**REQUEST**

Current Zoning: MX-1 (mixed use district)  
 Proposed Zoning: N2-A(CD) (neighborhood 2-A, conditional)

Approximately 33.95 acres located east of Bending Branch Road and west of Interstate 485, north of Albemarle Road.

The petition proposes to allow a 124-unit single family attached (townhome) residential community on vacant acreage previously approved to allow 75 single family detached homes.

REZONING PLAN
RZ.01

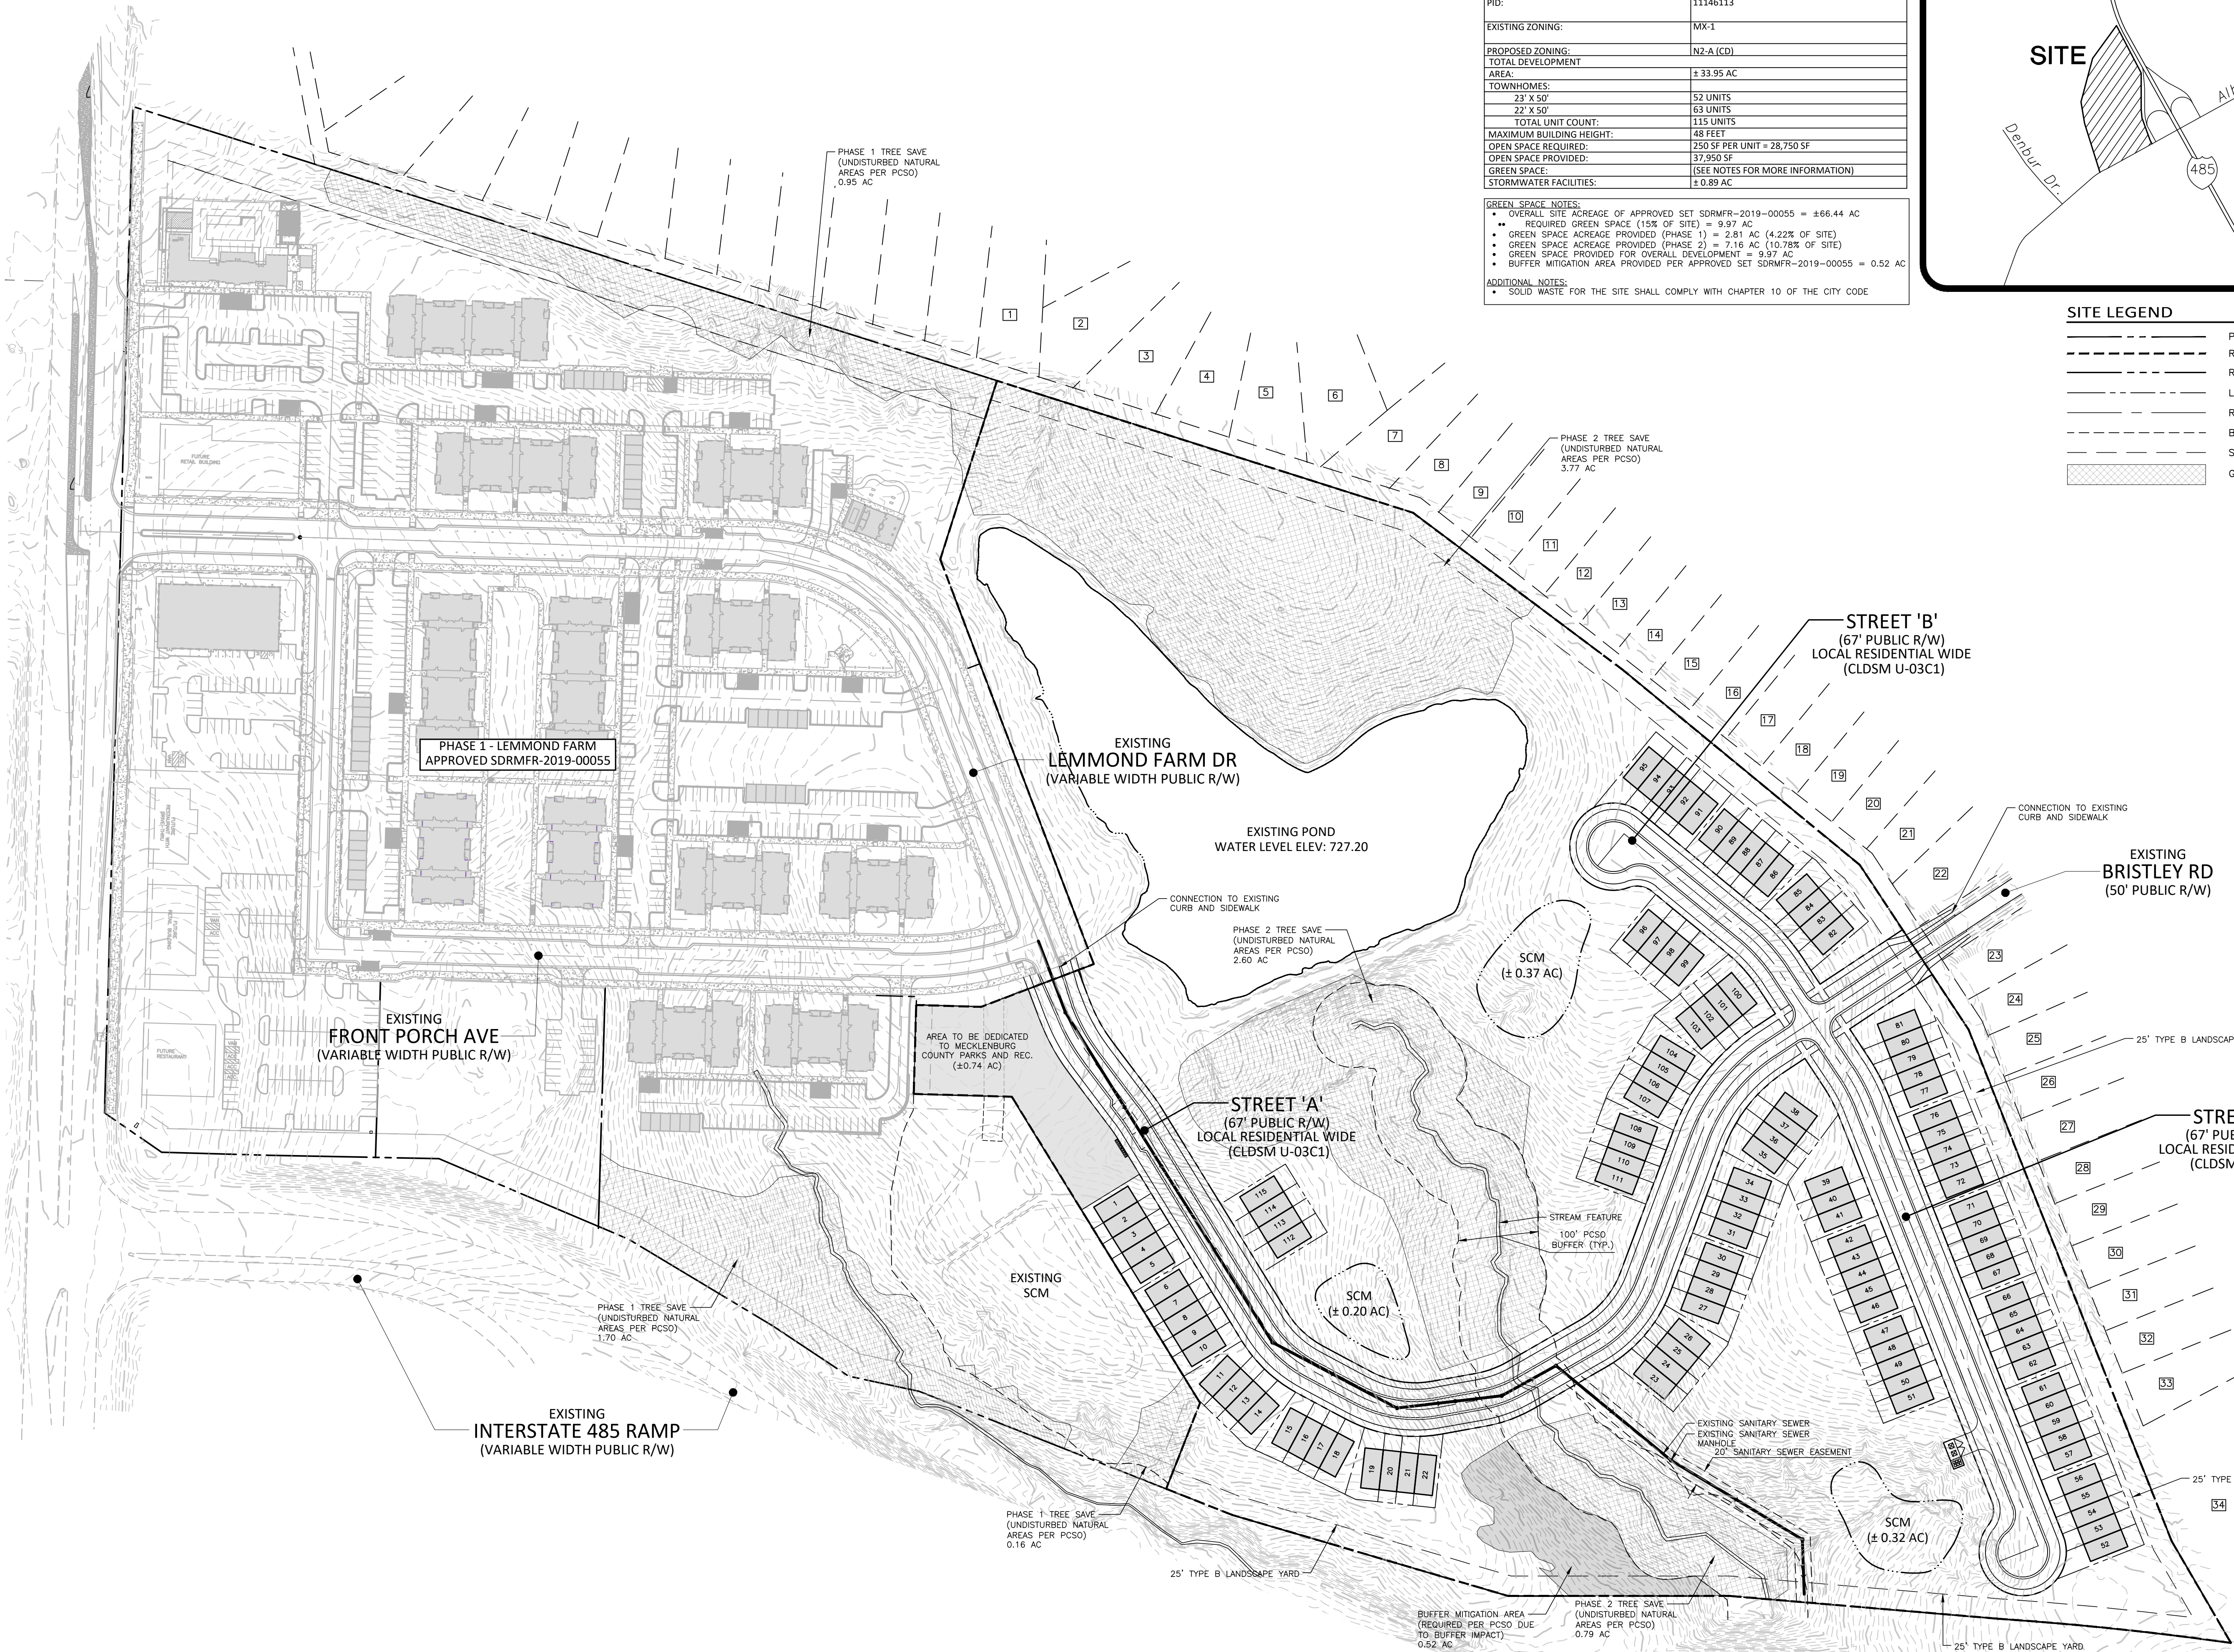
2. Please confirm with Zoning Administration if an administrative amendment is required as part of the process.
3. Label setback along Public Streets A and B.
4. Label zoning of abutting parcels, including next door NS zoning.
5. Note 1.d. limits the total number of buildings to 28, but 26 buildings are shown. Please revise so the graphic depiction of the plan matches the notes.
6. Please modify Note 4.b. to refer to "landscape yard".

7. Tree save does not appear to meet the referenced site plan.
8. Tree save has already been established. Green space location has already been determined per the previous plans.
